Our ref: DOC21/122900  
Senders ref: SSD (8996)

**Response to Submissions – Loreto Normanhurst School Redevelopment (Concept Proposal & Stage 1), 91-93 Pennant Hills Road, Normanhurst (SSD 8996)**

EES has reviewed the RtS table prepared by Ethos Urban dated 11 February 2021 makes the following comments;

Figure 4.1: Flood Planning Map

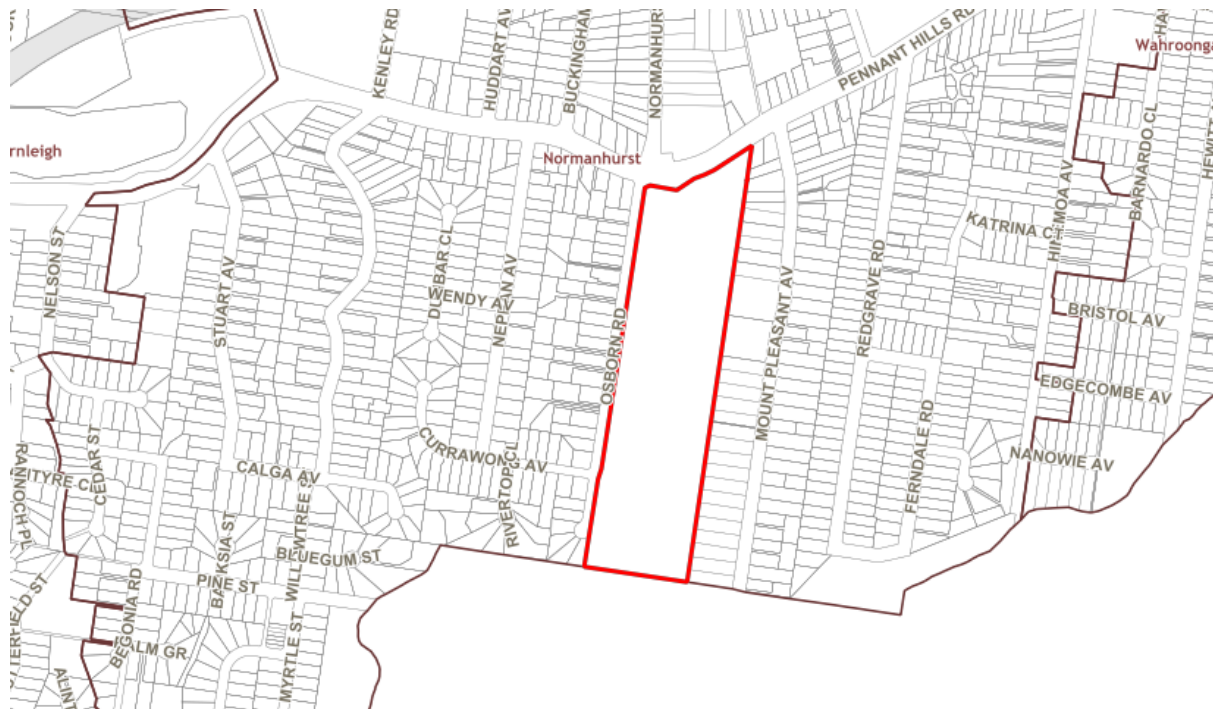
However, the Civil Engineering Report prepared by TTW refers to Hornsby Council's DCP 2013 and concludes that the proposed concept design does not appear to propose any obstruction to natural overland flow paths through the site. Therefore, no flood assessment has been undertaken.

- the latest flood studies and floodplain risk management study and plan undertaken by Hornsby Shire Council (Council) identify the site as impacted by overland flow flooding.
- the principles of the Floodplain Development Manual (2005) apply to urban lands affected by overland flow.
- the development is classified as vulnerable development considering its users' vulnerability and response during flood events.
- Consistency with Section 1 C3.2 of the amended Council DCP (2013), which was approved on 10 February 2021, is prudent.

- prepare a flood impact and risk assessment utilising Council's existing flood information to outline the base case overland flow behaviour for the full range of flooding up to the probable maximum flood (PMF).

- address developed scenario and assess the impact of the development on overland flow flooding and the impact of flooding on the development for the full range of flooding up to the PMF.

- identify management options required to mitigate any adverse impacts from the development and identify development controls required in accordance to 1 C3.2 of the amended Council DCP (2013).
